STATE OF NORTH CAROLINA  
DEPARTMENT OF TRANSPORTATION

March 22, 2013

**Subject:** Request for Modifications to the Section 404 Individual Permit and Section 401 Water Quality Certification for I-485 (Charlotte Outer Loop) from east of I-77 to I-85 in Mecklenburg County. Division 10, TIP's R-2248 E and R-2123 CE, Debit \$570 from WBS 34410.3.GV2

**Reference:** USACE Individual Permit Action ID SAW-2011-01237, dated Nov.22, 2011.  
NCDWQ Water Quality Certification No. 003868, dated October 14, 2011.  
NCDOT Modification Application dated June 4,2012  
NCDWQ Water Quality Certification Modification dated Jun 21, 2012

Permit Drawing  
Sheet 44 of 108

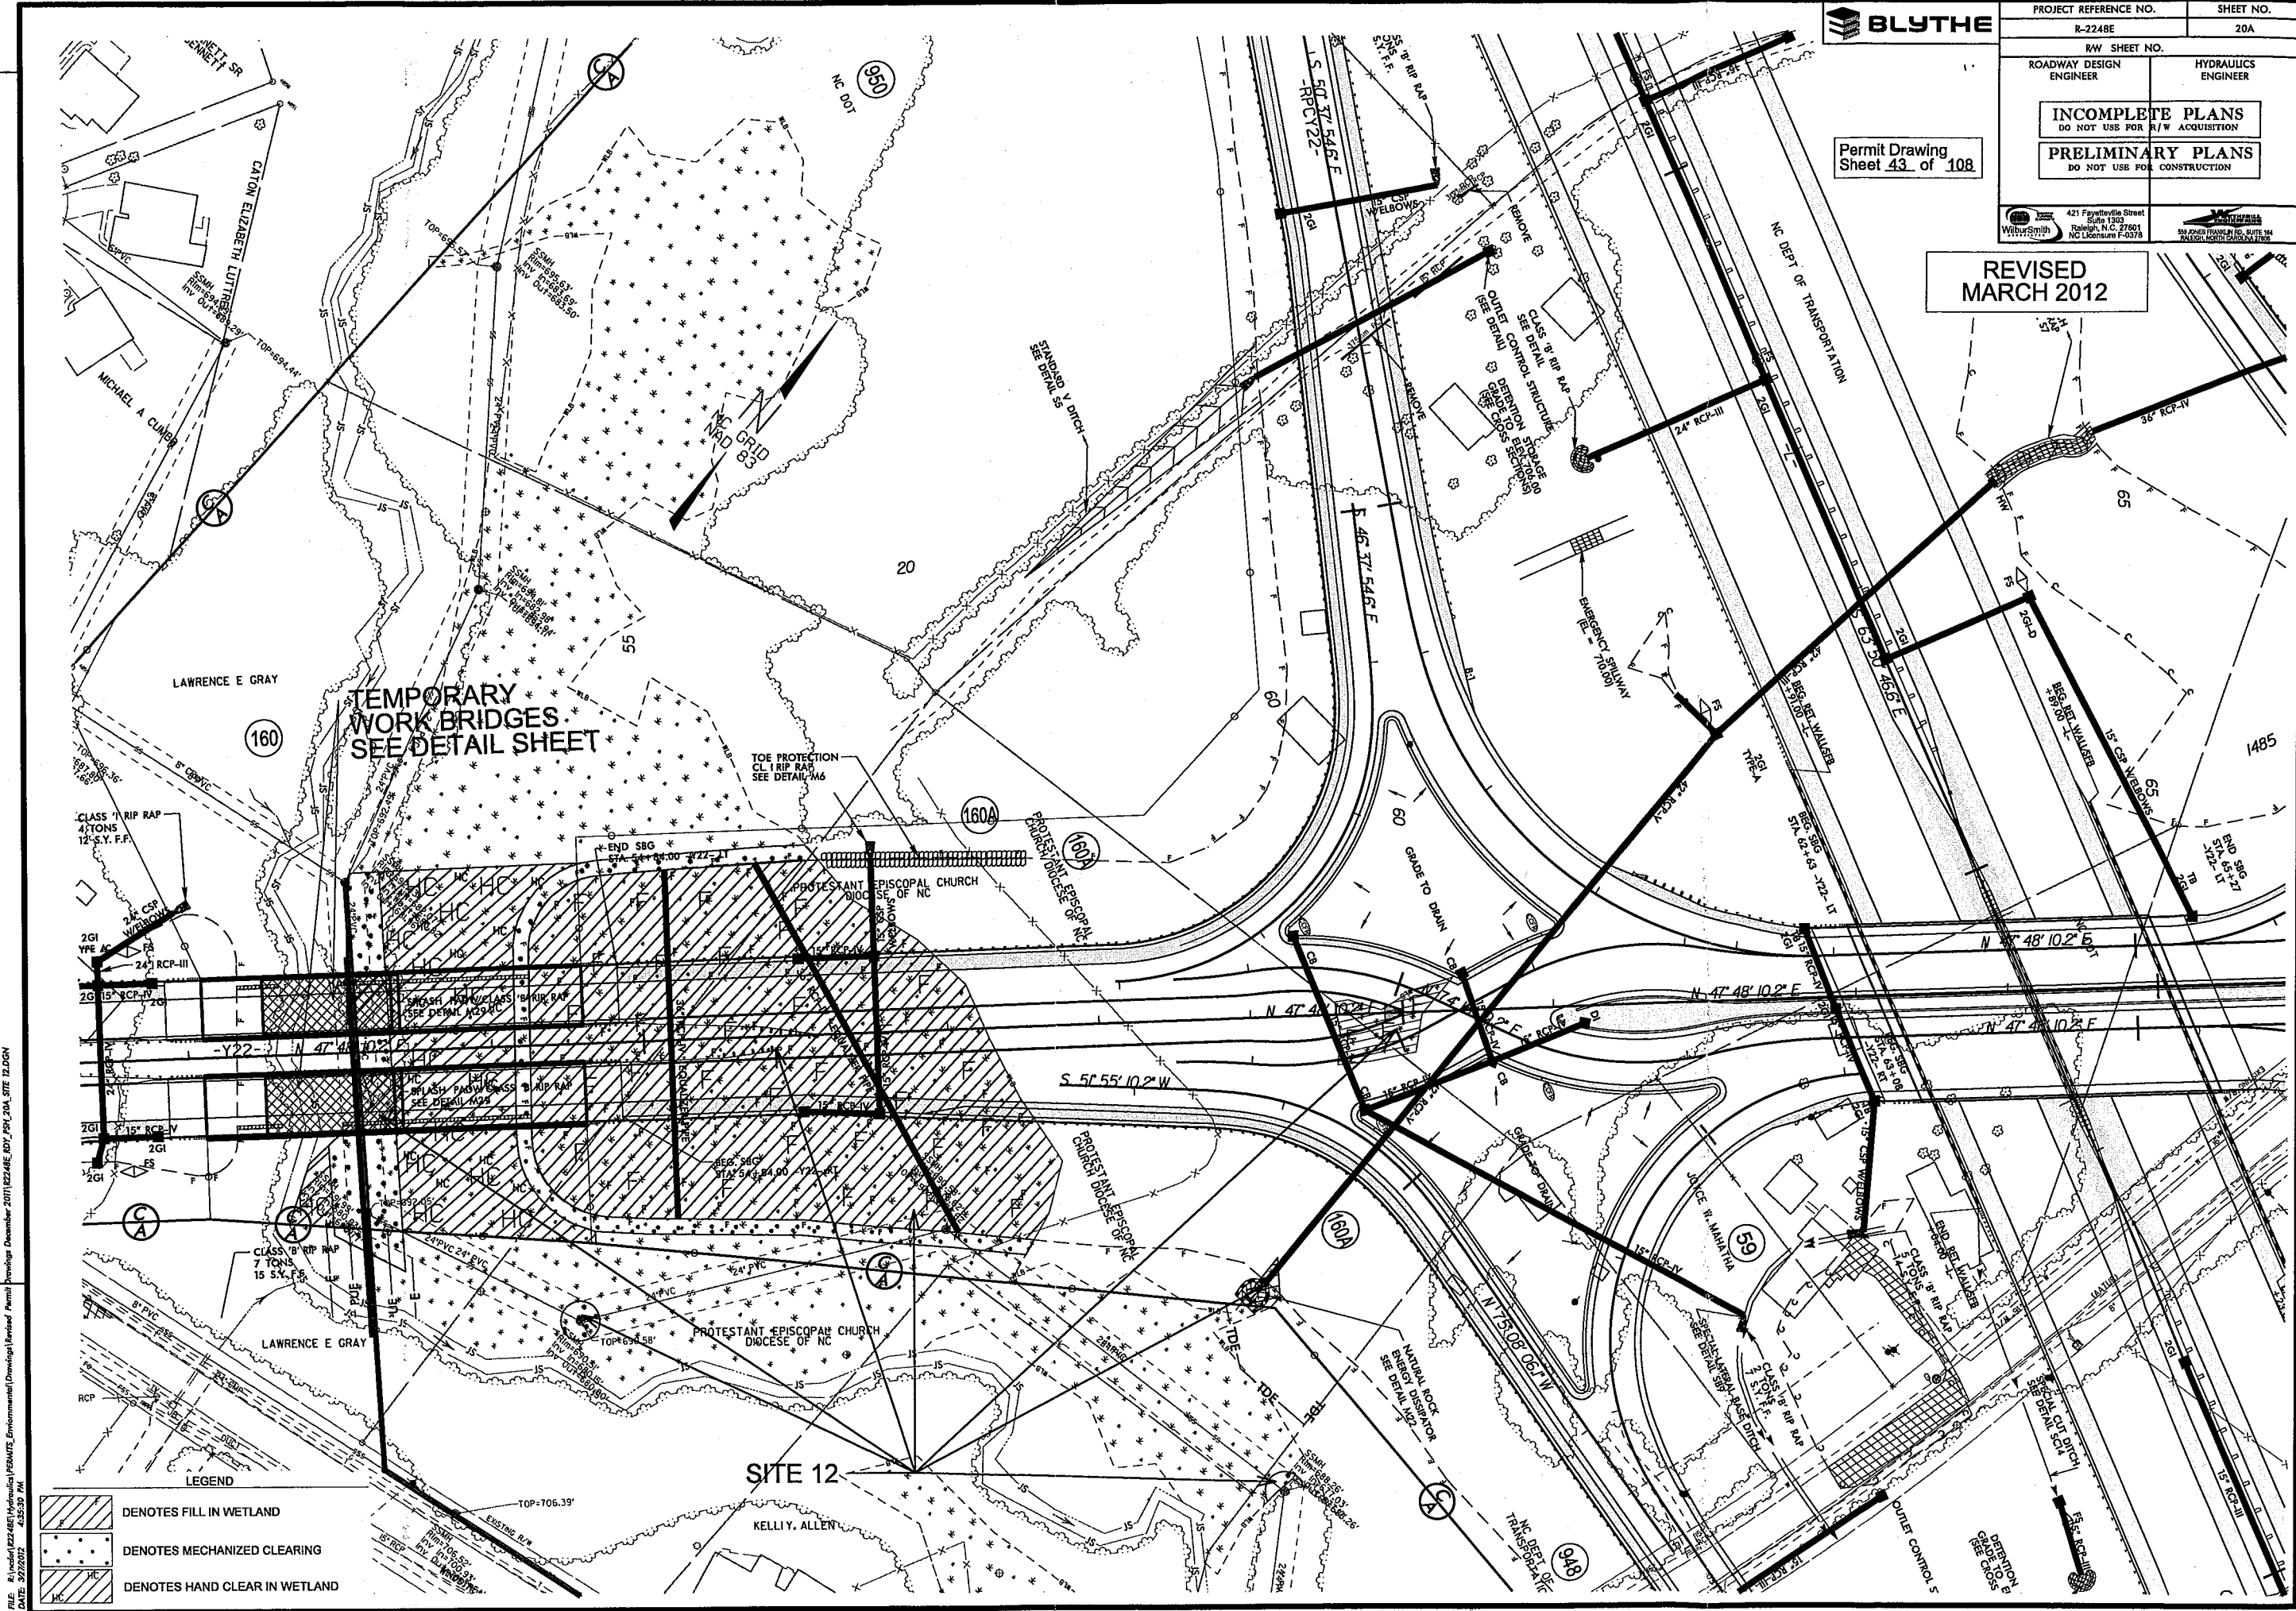
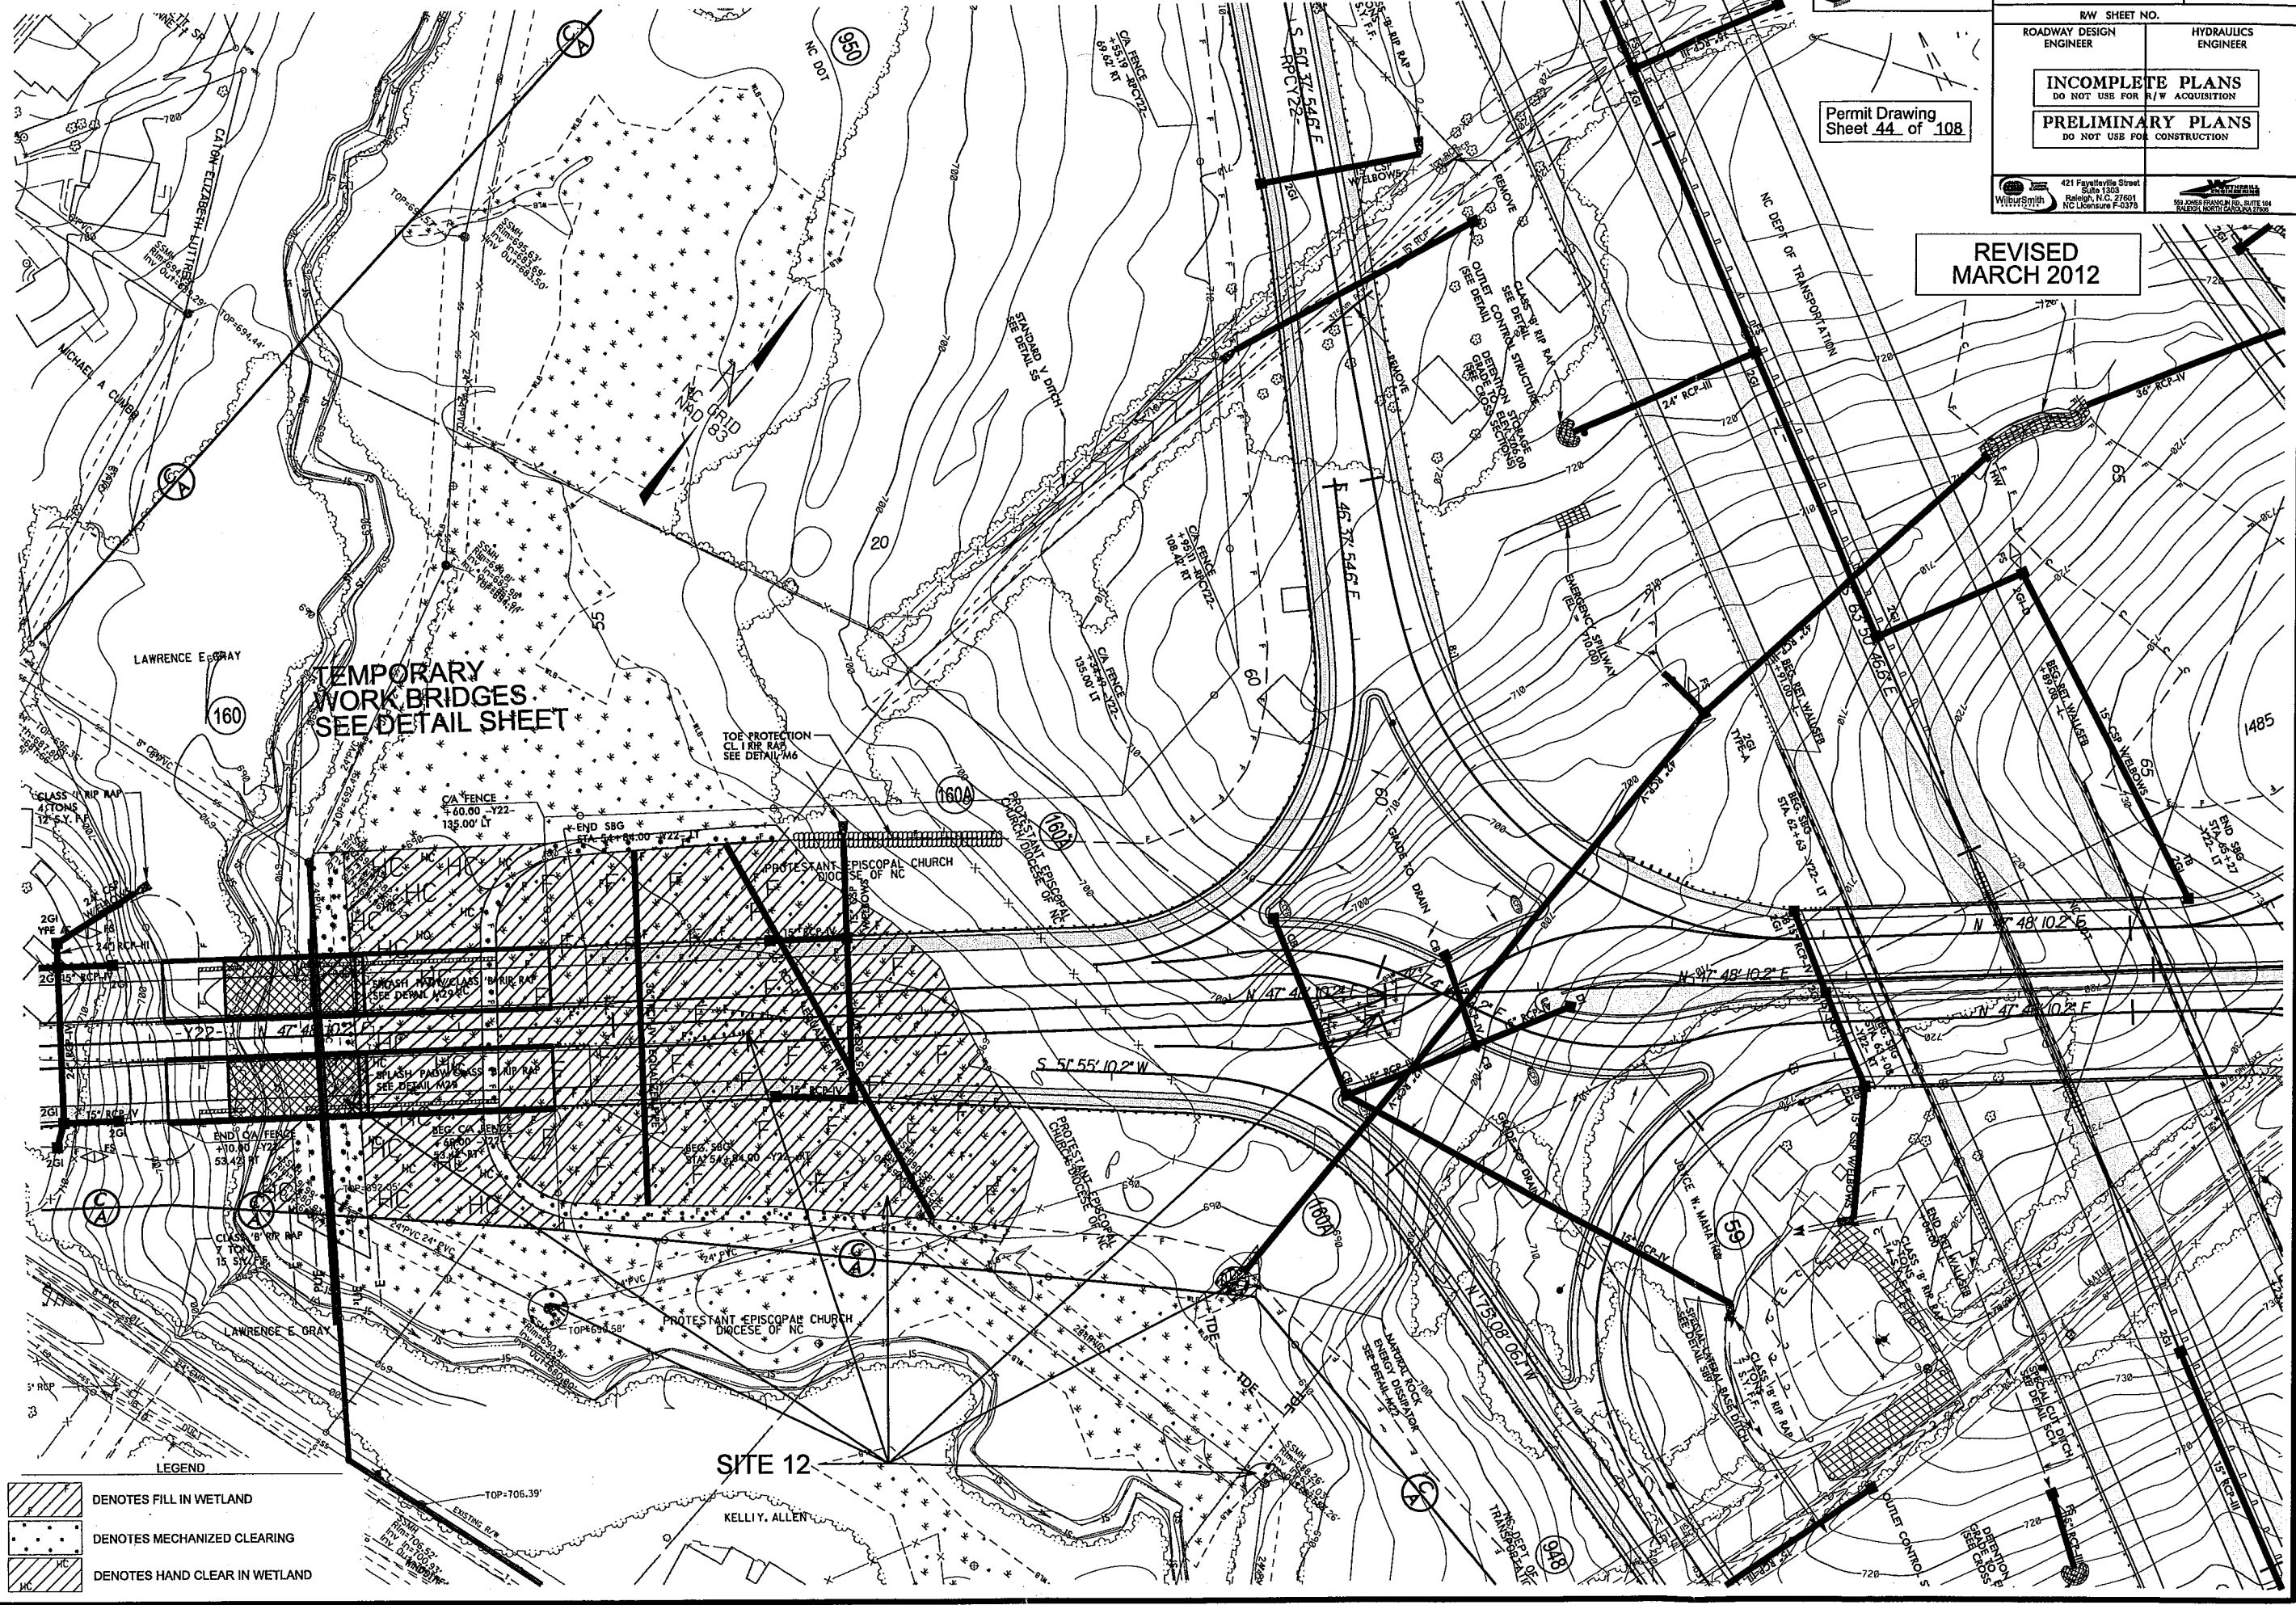
**Revision:** An increase in impacts from 0.164 to 0.799 acre of mechanized clearing (+0.635 acre riparian wetland)  
An increase in impacts from 0.0 to 0.262 acre of excavation (+0.262 acre riparian wetland)  
A decrease in impacts from 0.612 to 0.497 acre of hand clearing (HC) (-0.11 acre riparian wetland)  
Note- the HC area will now be considered for mitigation due the change in the wetland type/function.

**Reason:** A new sewer line will cross portions of Wetland WBA increasing the excavation and mechanized clearing impacts – this sewer line was re-routed due to constructability issues.

Permit Drawing  
 Sheet 46 of 108

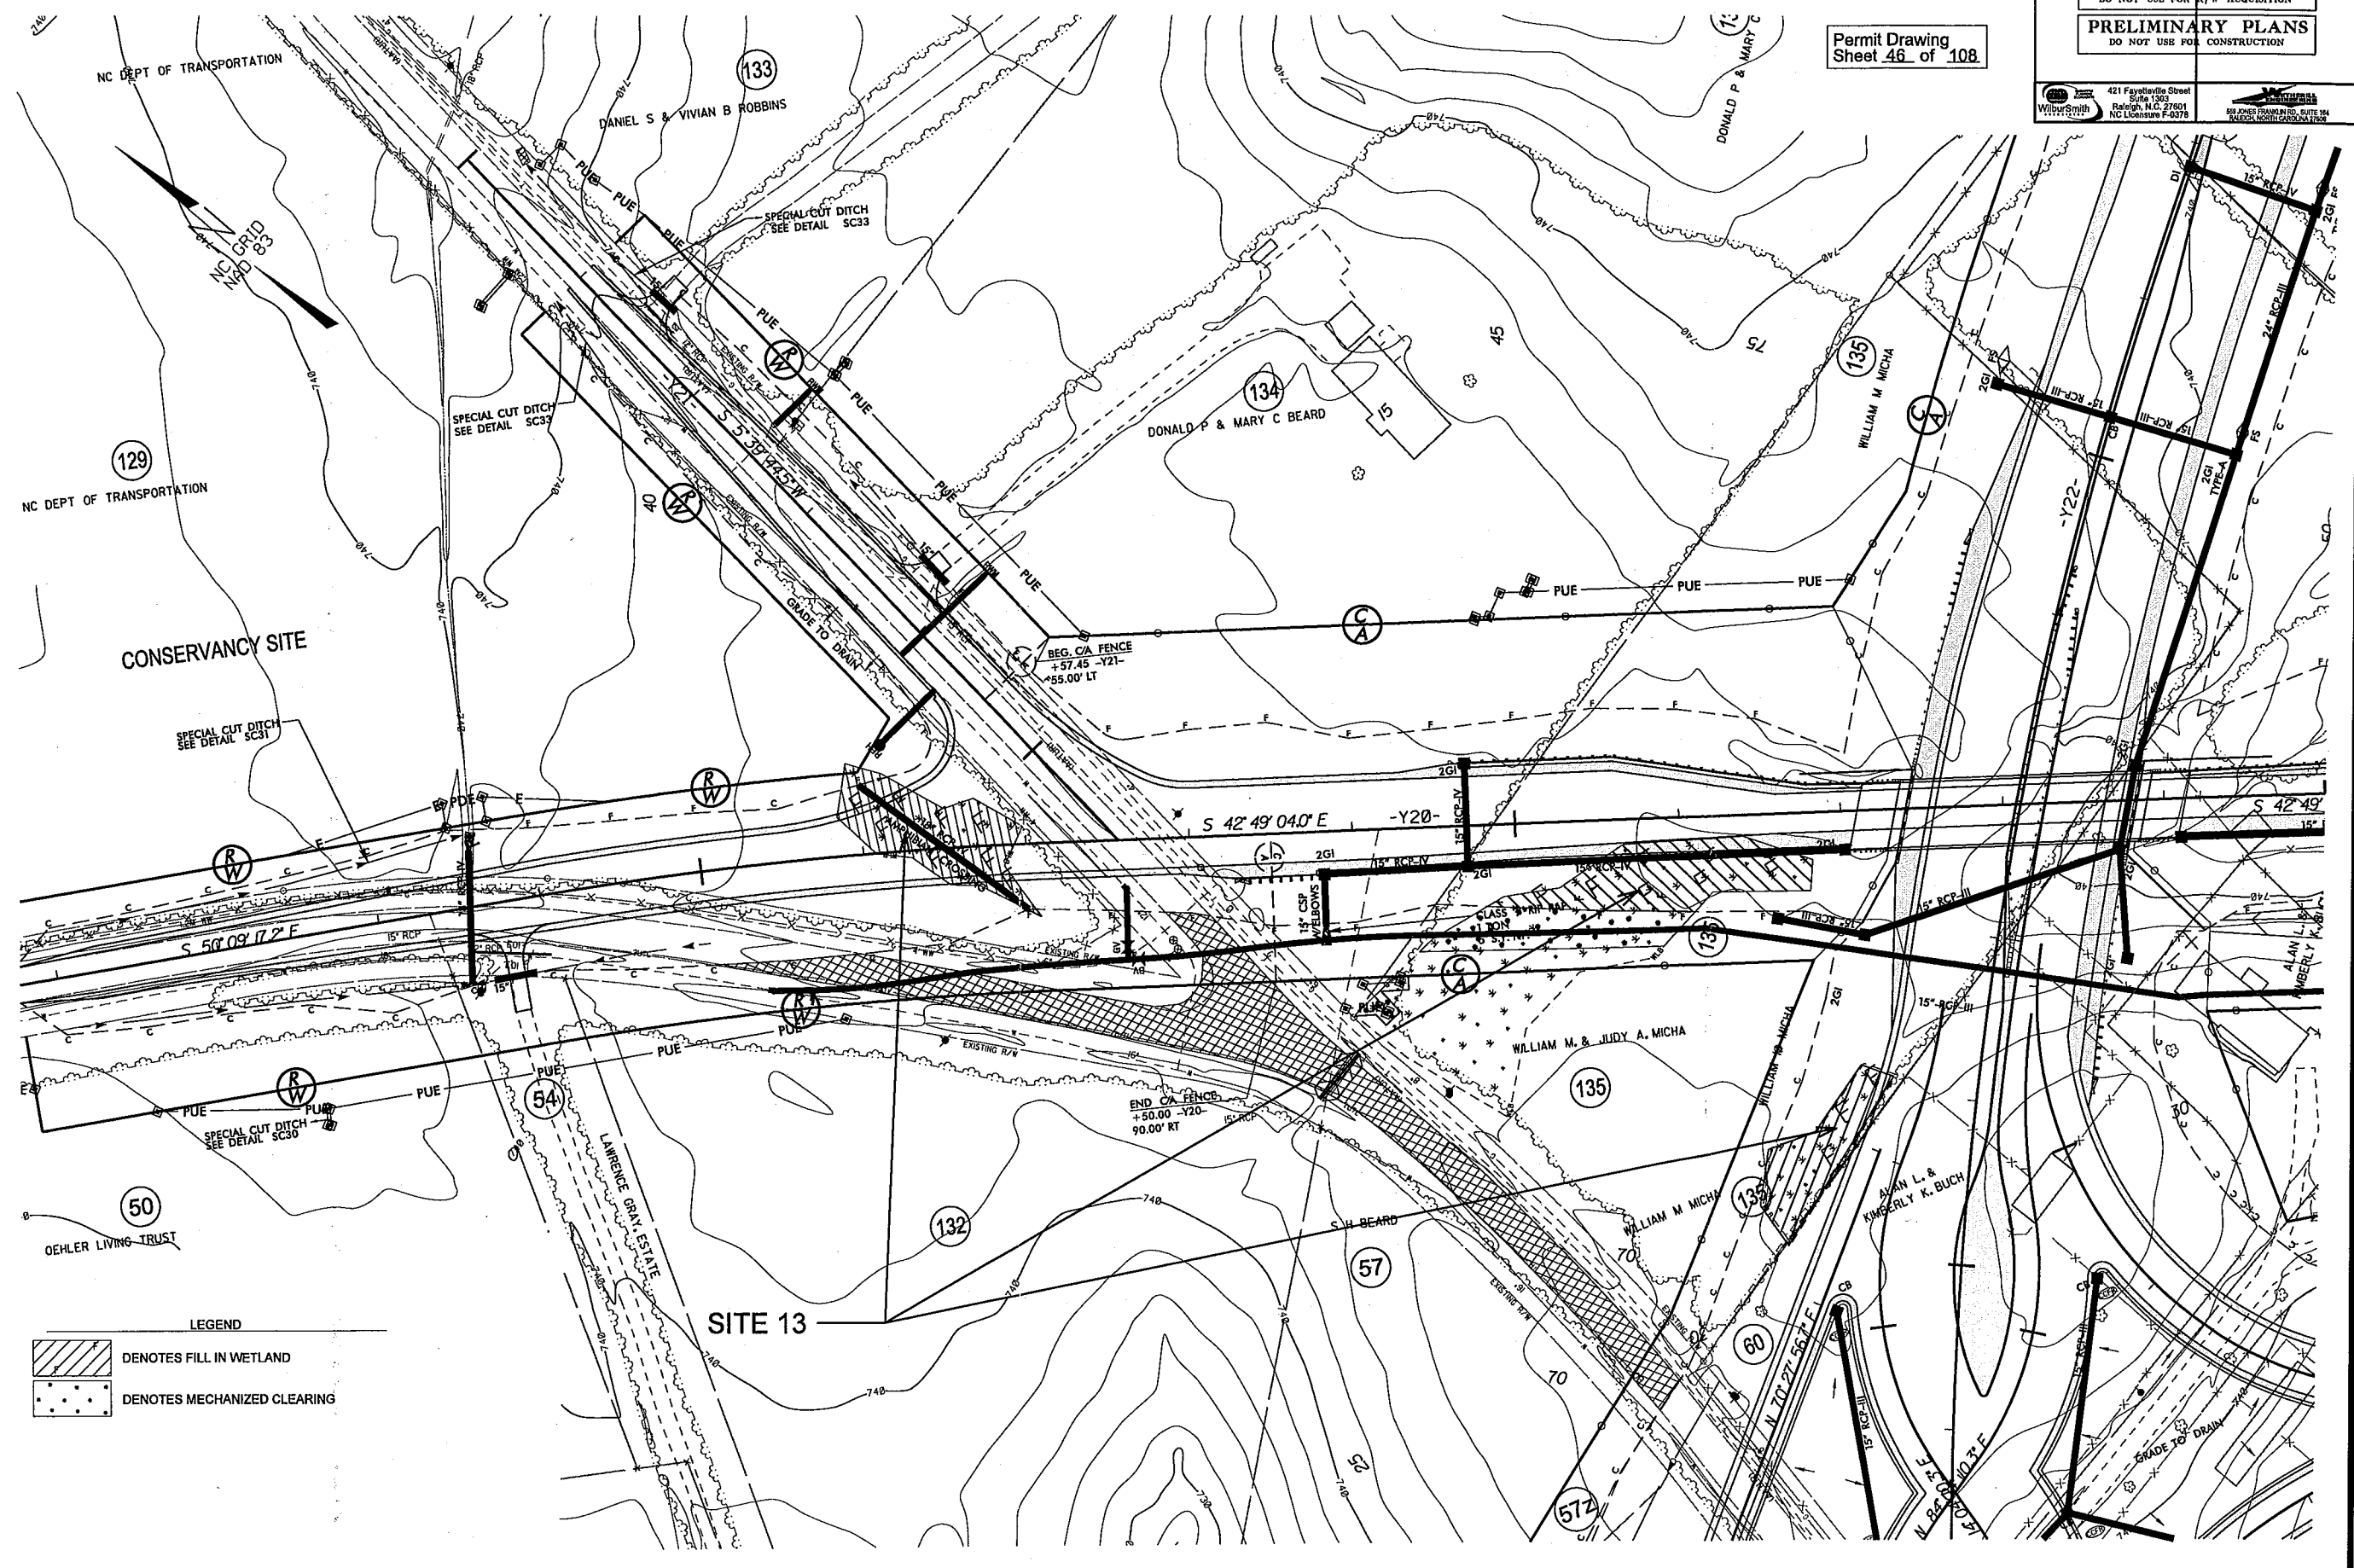
**Revision:** An increase in impacts from 0.03 to 0.12 acre of mechanized clearing (+0.09 acre wetland)  
An increase in impacts from 0.0 to 0.03 acre of excavation (+0.03 acre wetland)  
Note – increased impacts at this site are to non-riparian wetlands.

**Reason:** Water line and utility pole guy-wire anchors added, south of Y22.
